Application for DCO by FOSSE GREEN
Summary of Representation by Interested Party reference [REDACTED]
Deadline 2

1. This representation comprises my comments to the Applicant's response to Written Representations (REP1-047).

Noise Contours - Operational Phase
Distributed BESS

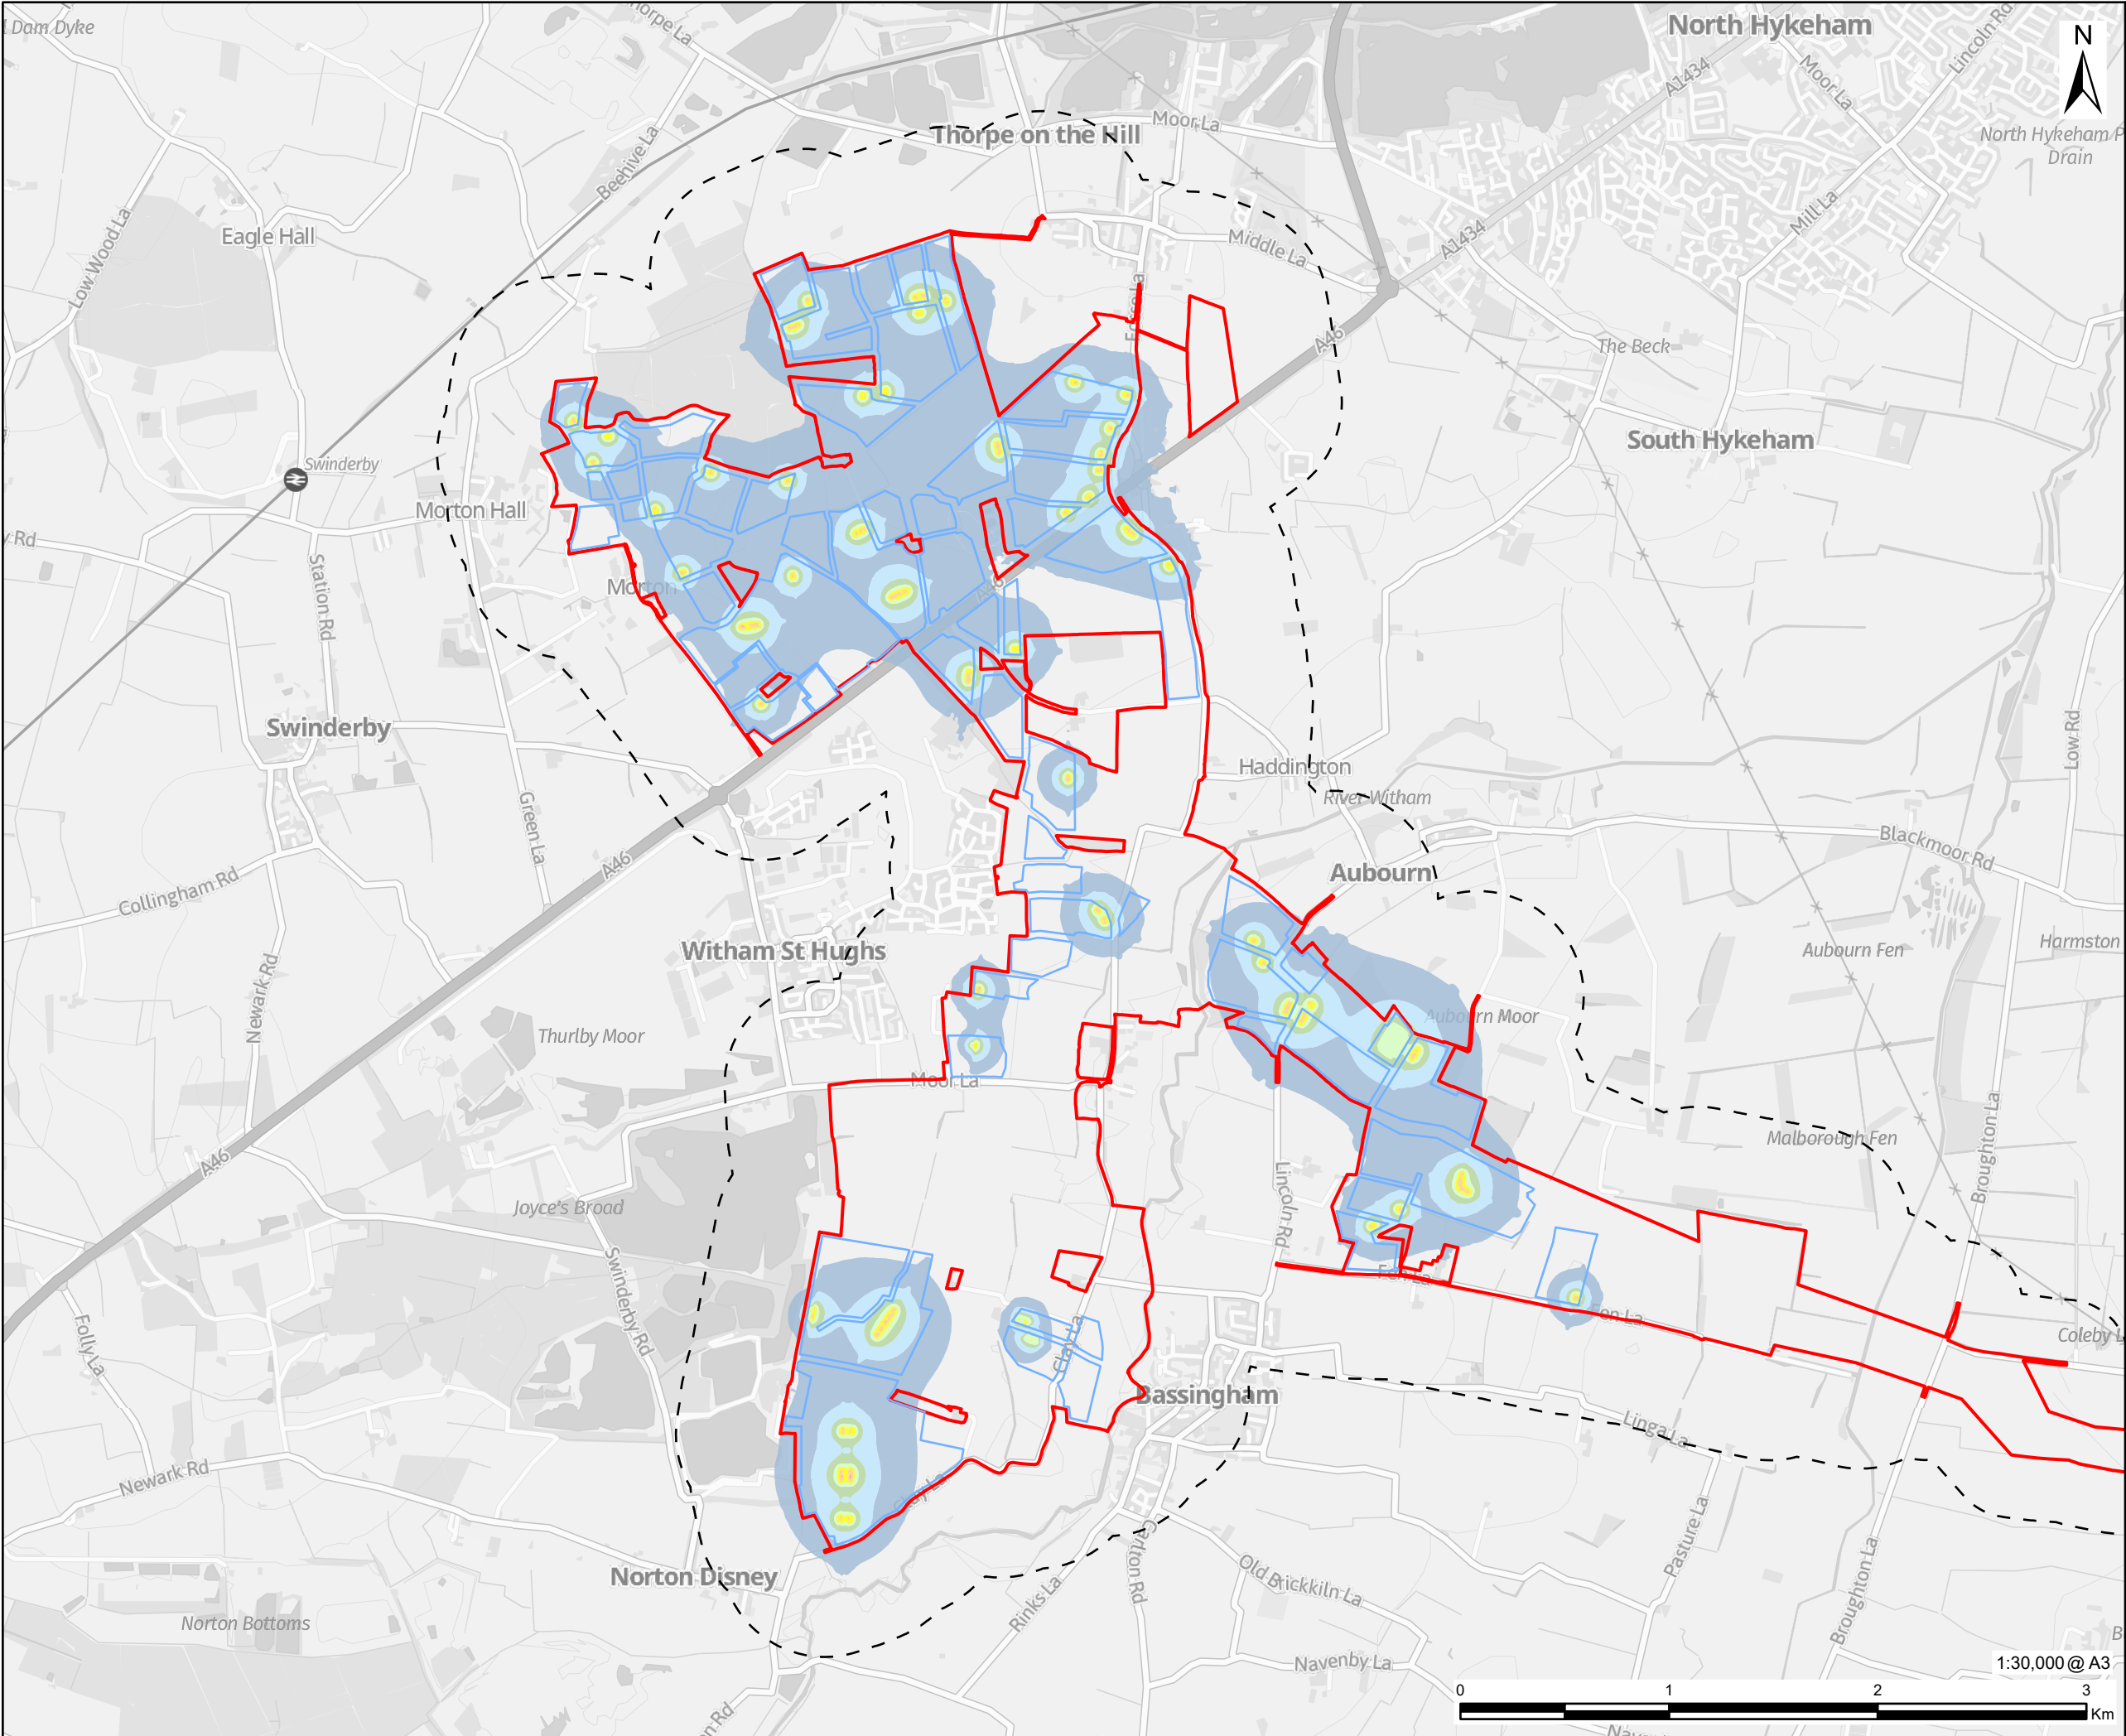
7. The WHO guidelines consider adverse health effects according to specific environments. The reference to an outdoor living area in the guidance is to areas such as residential gardens or balconies. More akin to the PRoW is the environment described as "Outdoors in

parkland and conservations areas” where the guidelines state that existing quiet outdoor areas should be preserved.

8. The Applicant asserts that the levels of operational noise along the PRoW are akin to the existing sound environment as evidenced by the baseline sound surveys. None of the monitoring locations for the sound surveys were on the PRoW. The applicant has therefore no evidence of the existing noise levels along the PRoW.
